RE: 571 Allen Avenue – 399-E-002 & 003 – R-3 Zone – determination letter

I am in receipt of your request to determine whether your lots held in common and located at 571 Allen Avenue may be divided into two separate lots that meet the underlying R-3 zoning requirements.

Based upon a submitted survey, signed and stamped by Daniel J. Dalfonso, and dated 01-15-2008, drawing number 1216, I have made the following determinations.

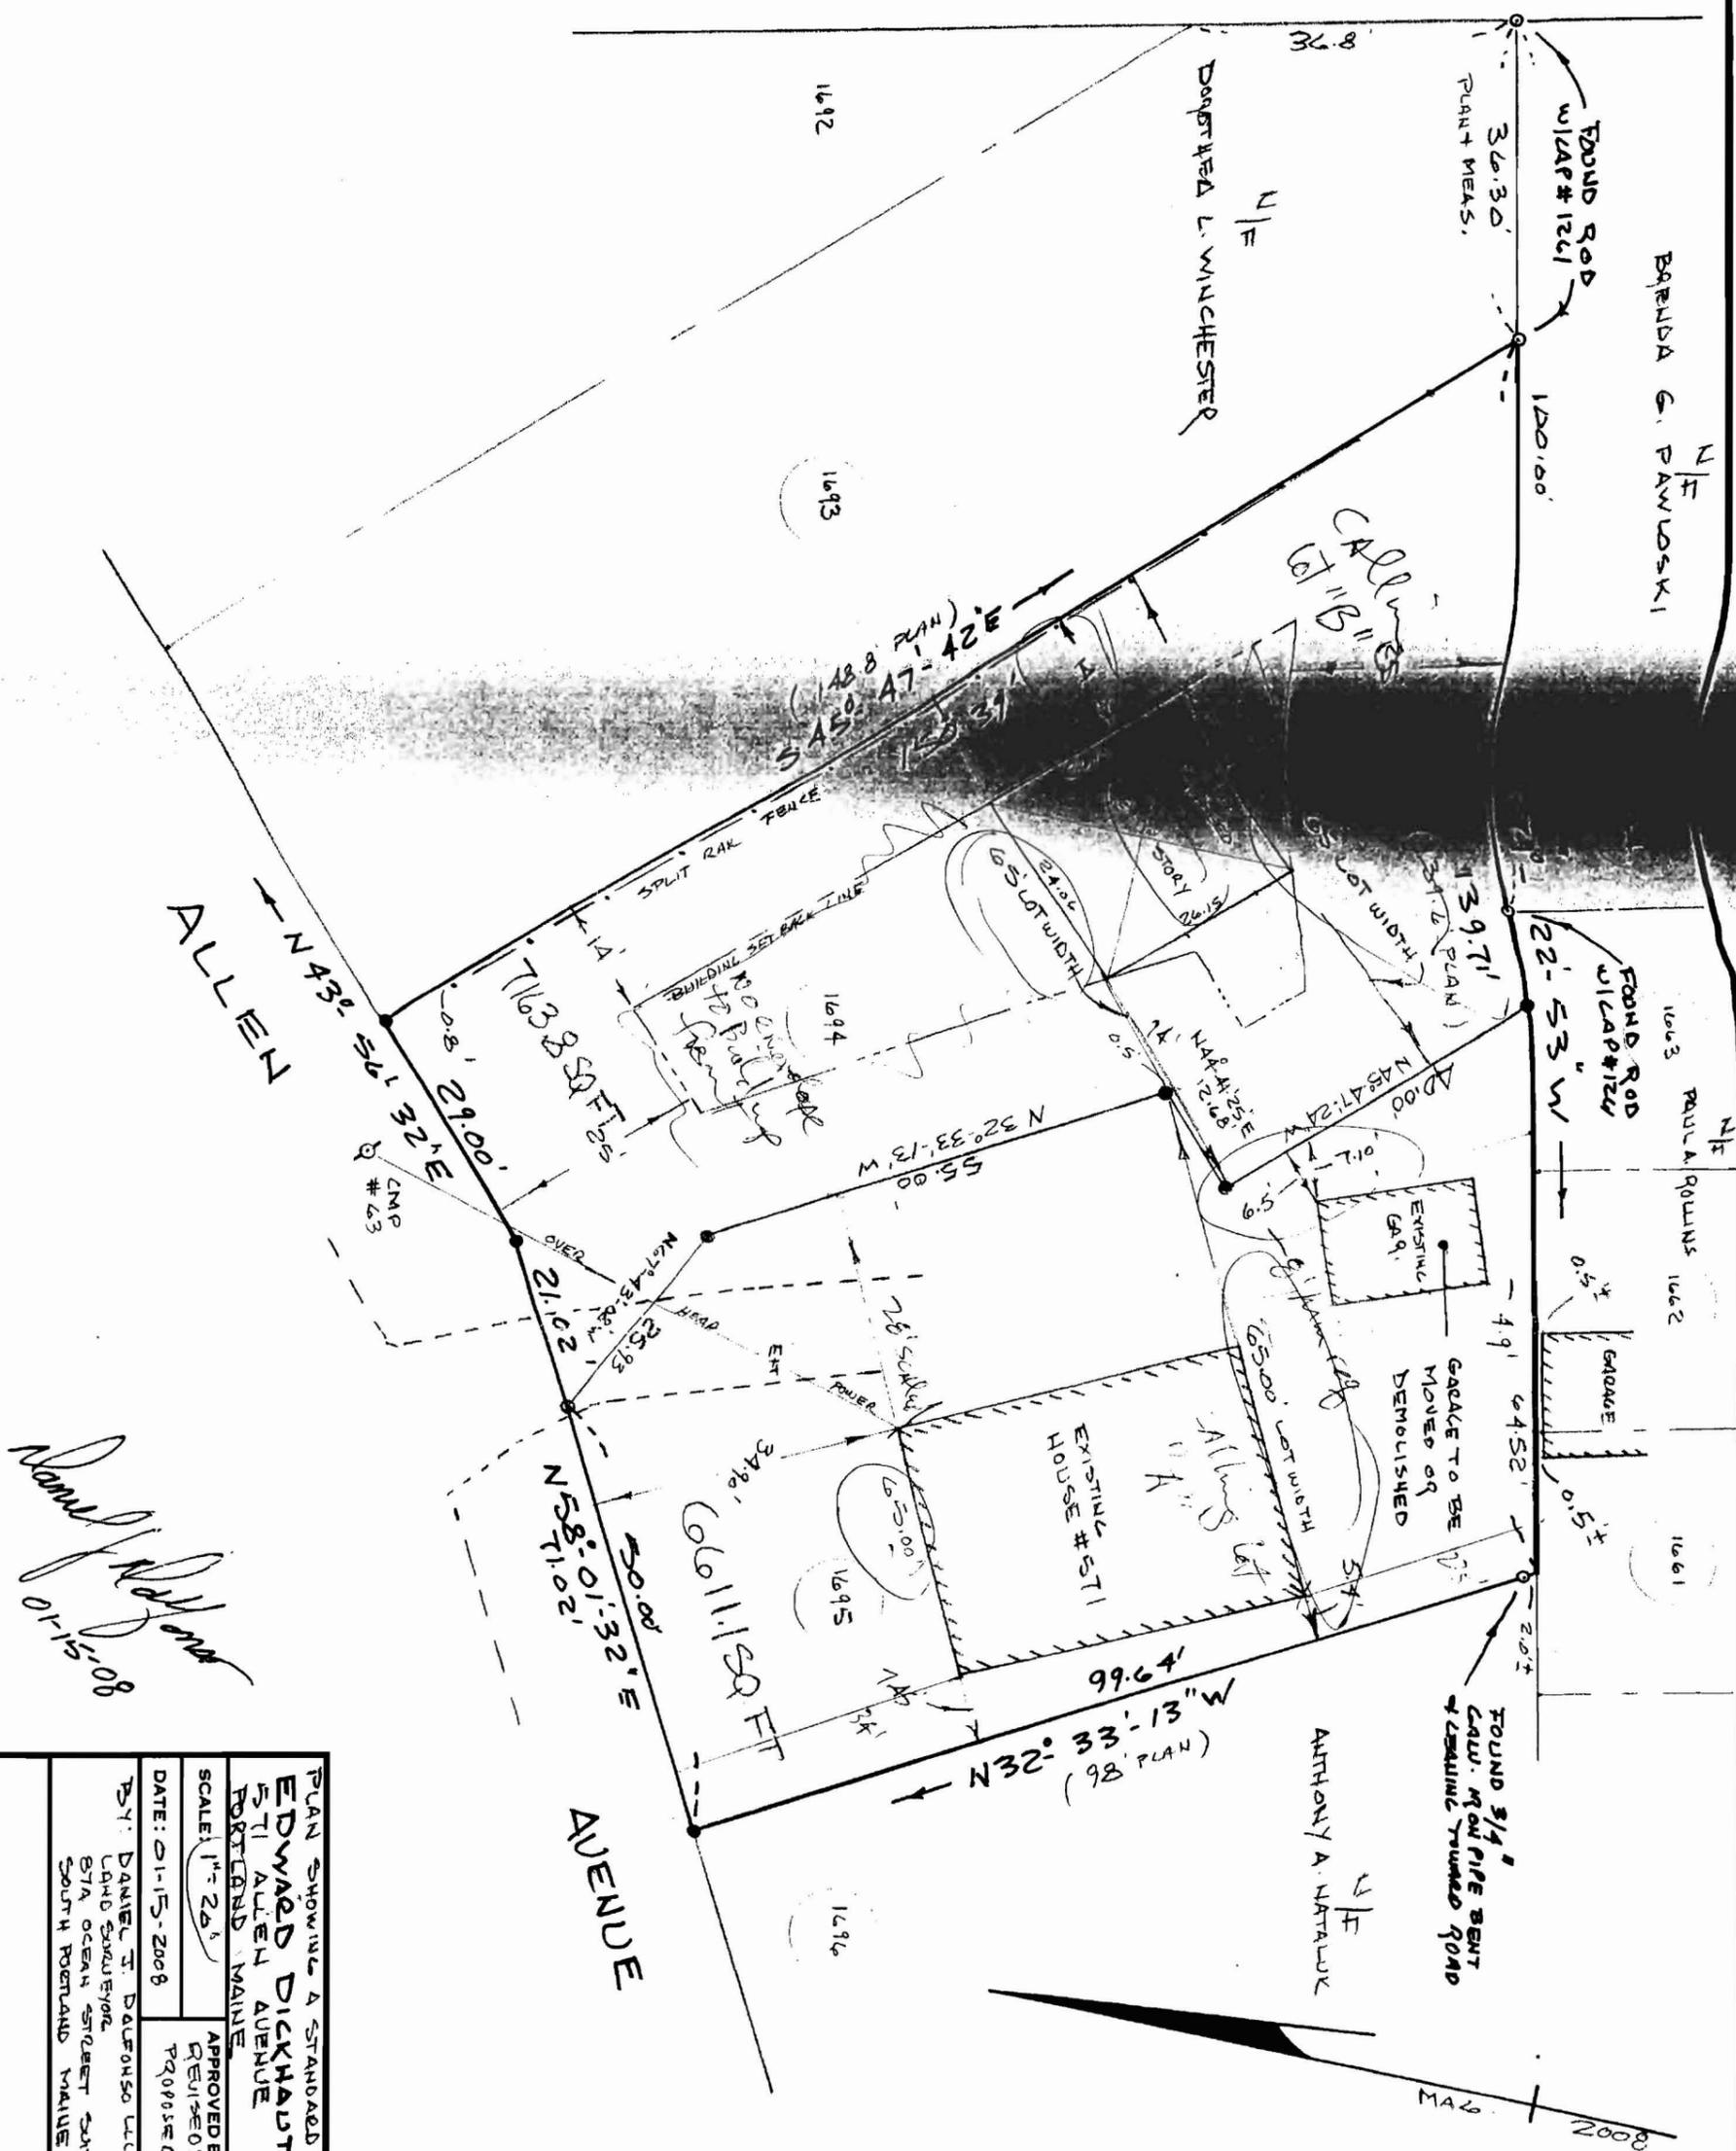
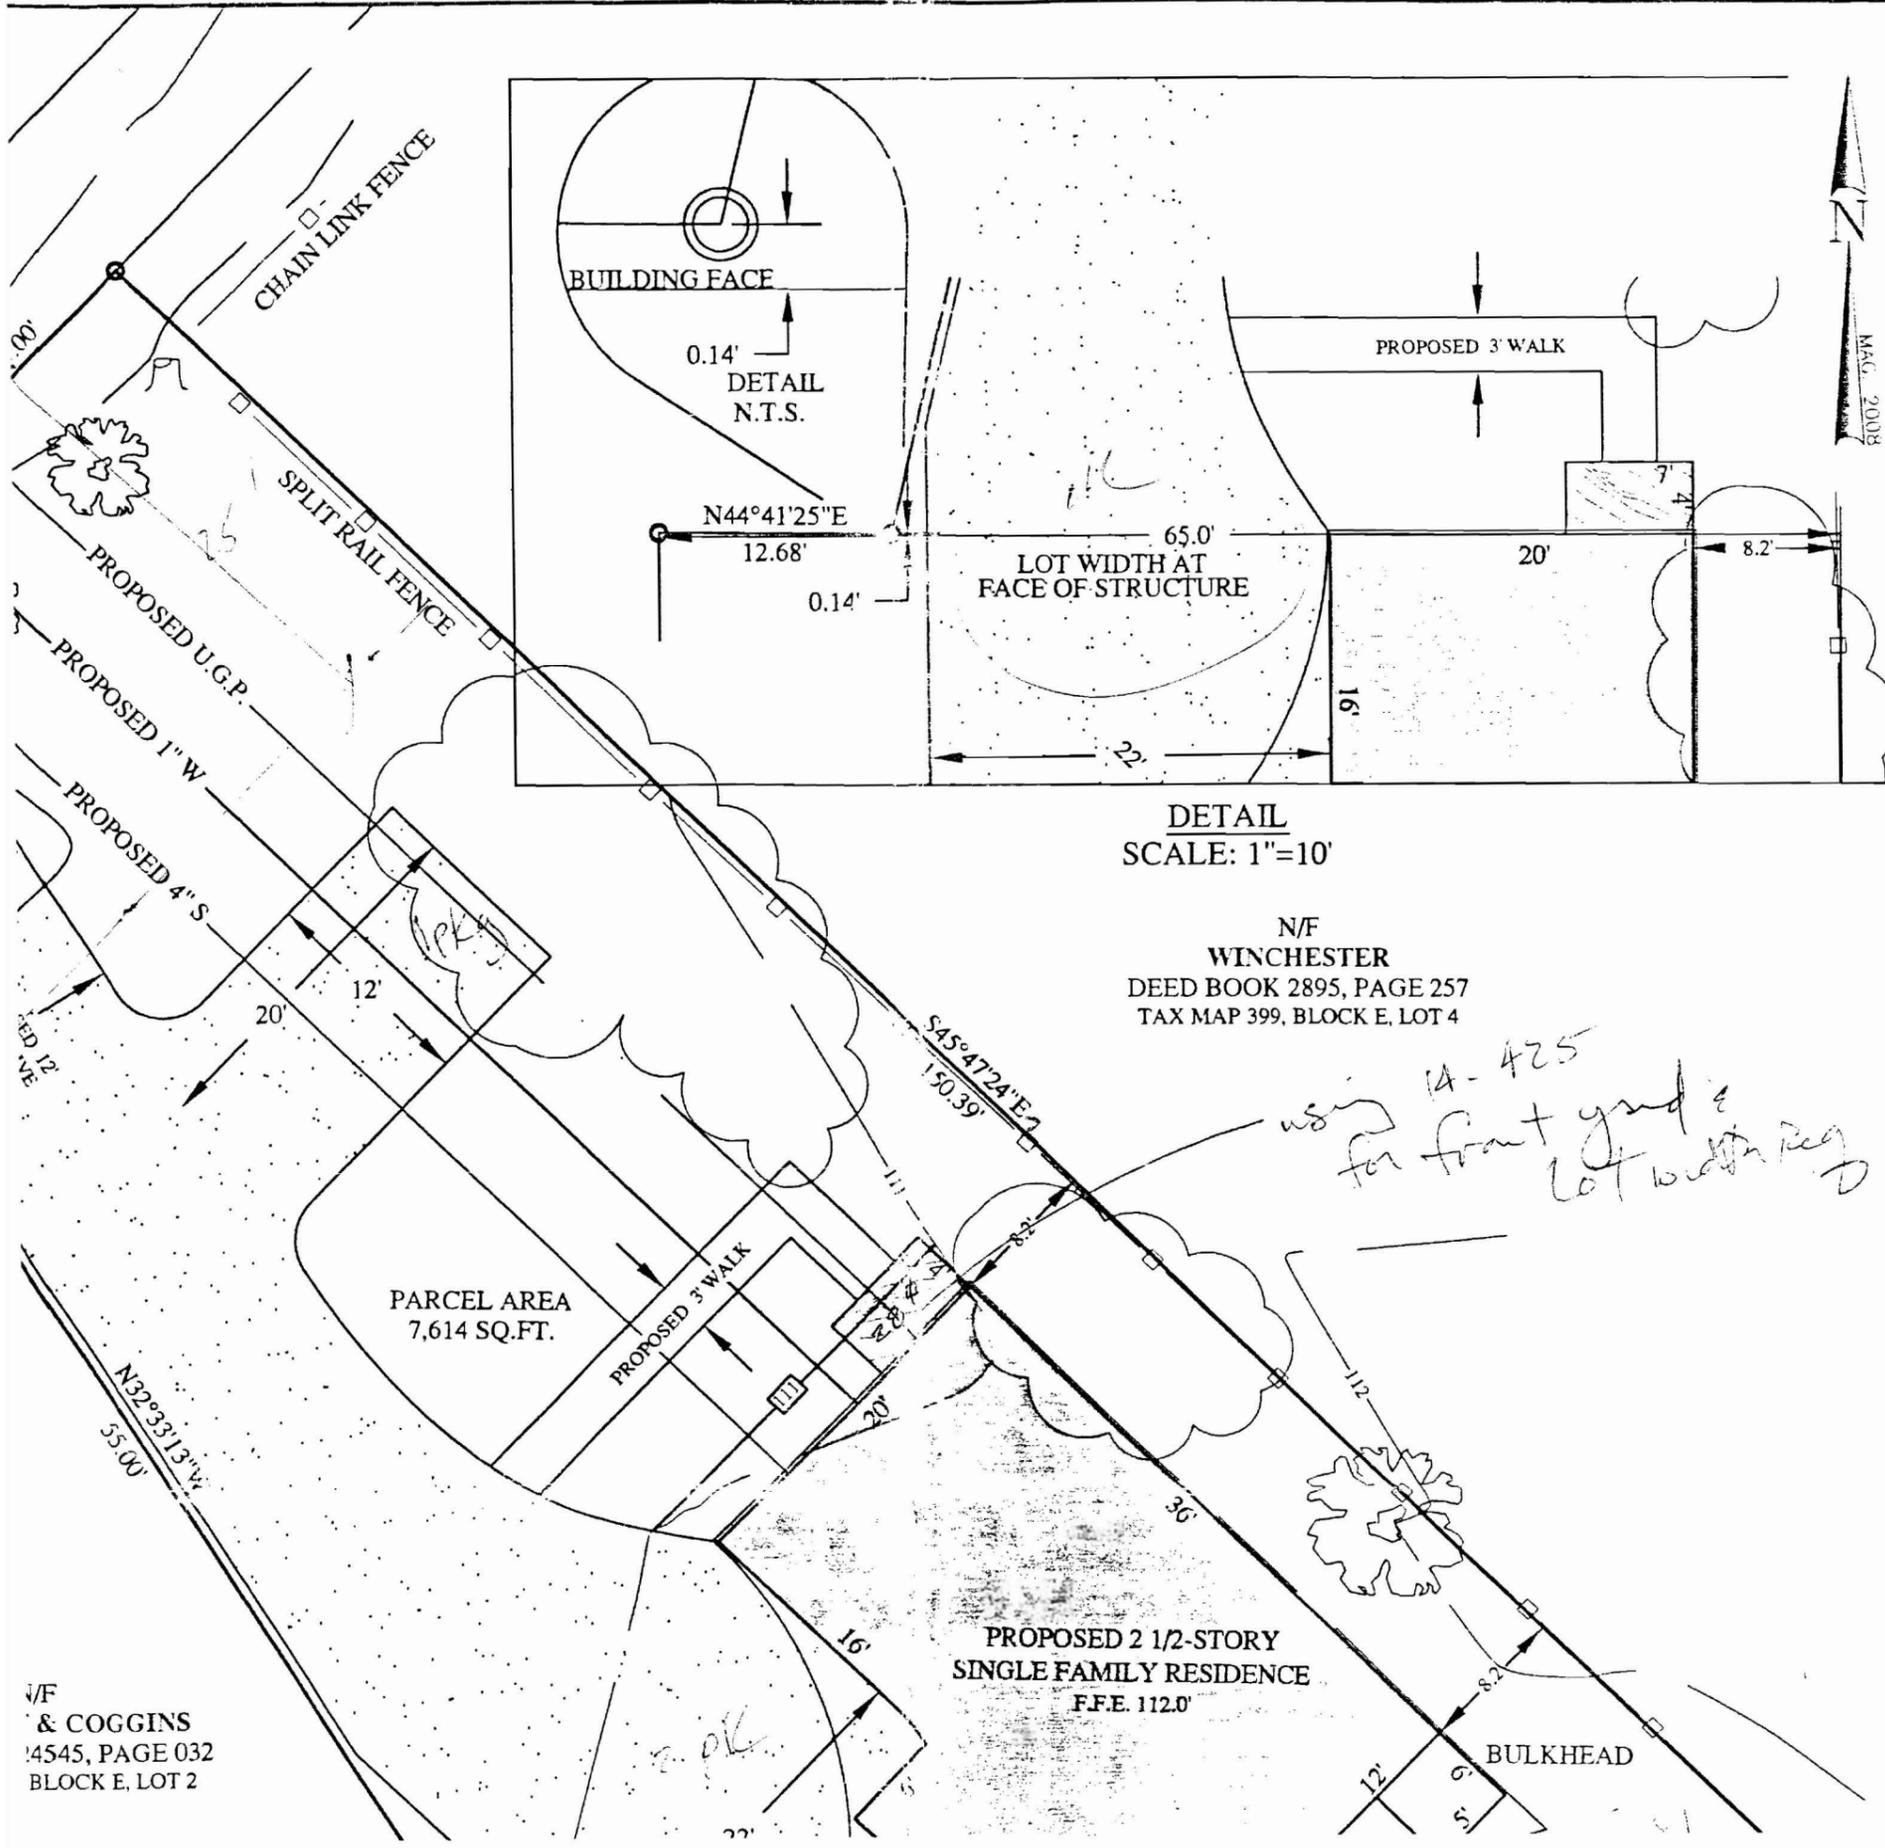
The lot division as proposed does meet the underlying R-3 zoning requirements with several conditions. The existing garage shall be removed prior to final approvals and the selling off of the new lot. The survey plan also erroneously depicts a building setback envelope with in the front area of the new vacant lot where it can not be built upon because it does not have the minimum required lot width. The survey plan shall be revised to eliminate those erroneous building setback lines.
